Stephen Kilmartin
Planning
Ribble Valley Borough Council

Ecological comments

Planning Application No: 3/13/0169

Location: Pendle Garage, Clitheroe Road, Barrow, Clitheroe

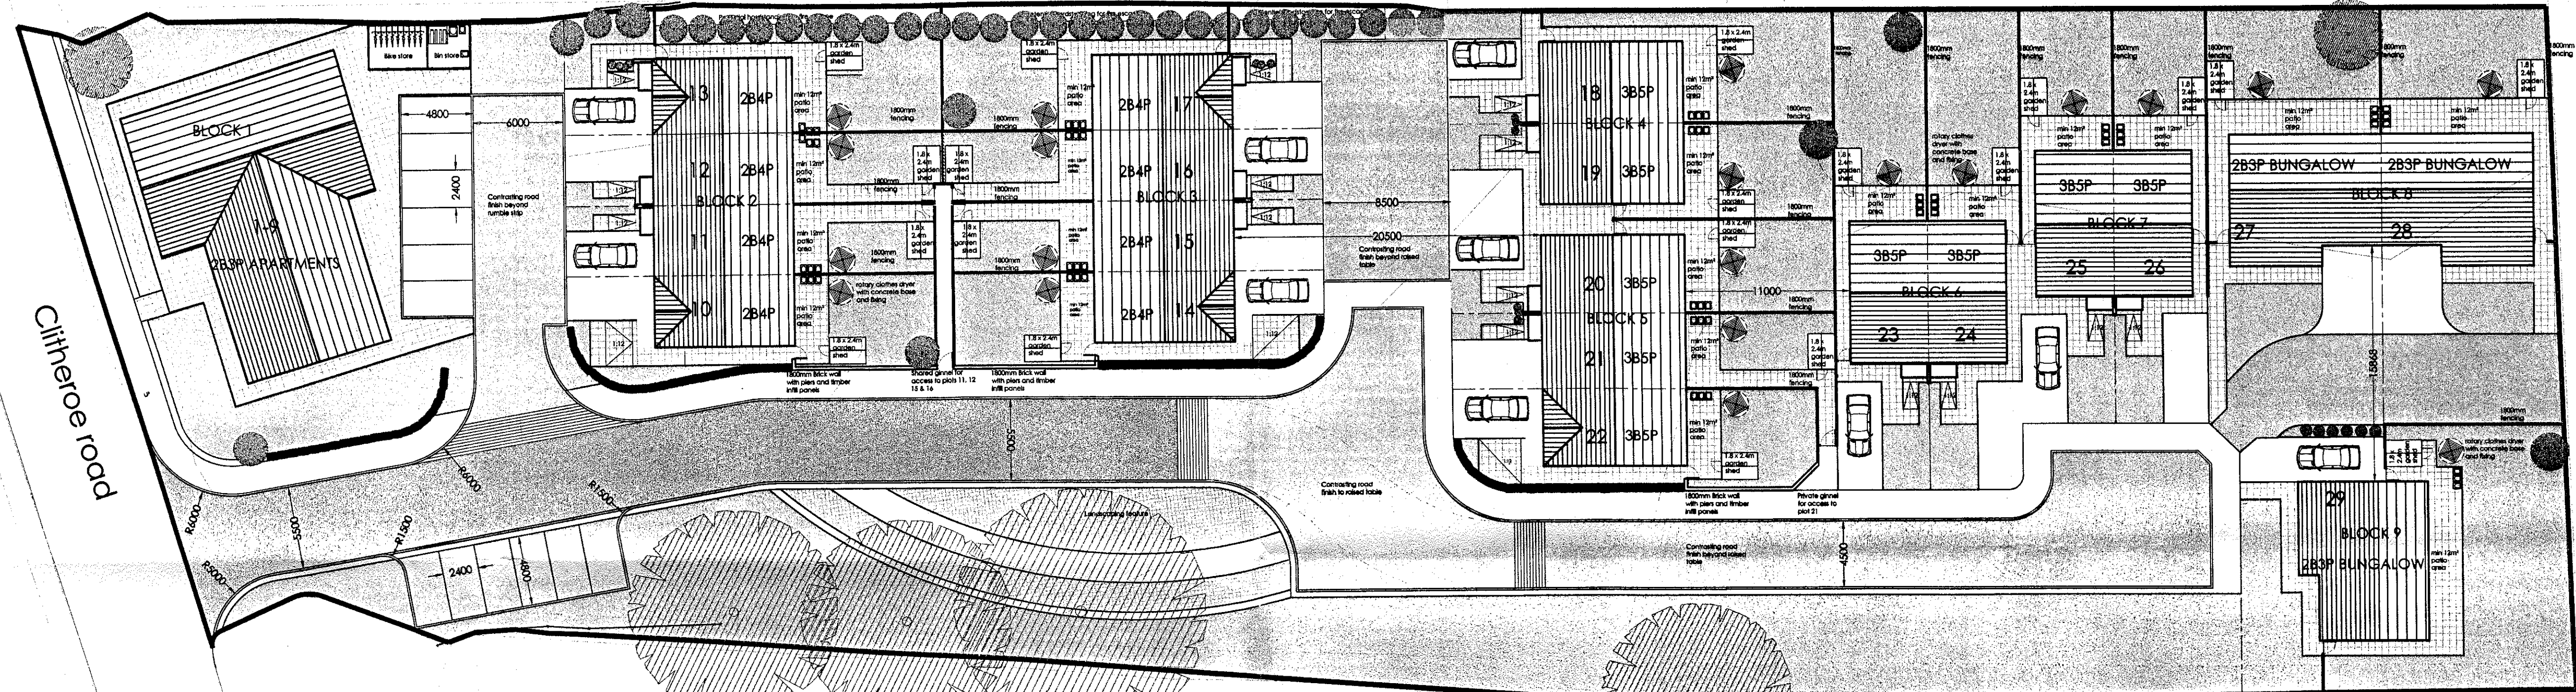
Whilst the D&A Statement indicates that ecological features are to be enhanced, it does not appear (from the proposed plan) that semi-natural habitats have been retained within the design of the development or that additional habitat creation has been provided to compensate for the loss of habitat. It is also not clear from the proposed plan whether there is sufficient space within the current layout for such habitat compensation/creation. This should be clarified prior to determination of the application.

If impacts are unavoidable, then there will be a need to adequately compensate for the losses. Although the proposed plan appears to include the retention of some of the trees along the southern boundary, in my opinion, the proposed plan does not adequately compensate for the proposed losses.

There may be opportunities, to retain habitat where possible, to provide compensation for losses and to ensure that habitat connectivity is retained, for example: through the retention and enhancement of the existing hedgerows and trees, provision of further hedgerow creation to provide habitat connectivity, provision of a semi-natural buffer along the edge of the hedgerows, provision of further semi-natural habitat (for example along the southern boundary of the site), provision of bird nesting and bat roosting opportunities within the design of the development (e.g. within the fabric of the buildings, bird/bat boxes).
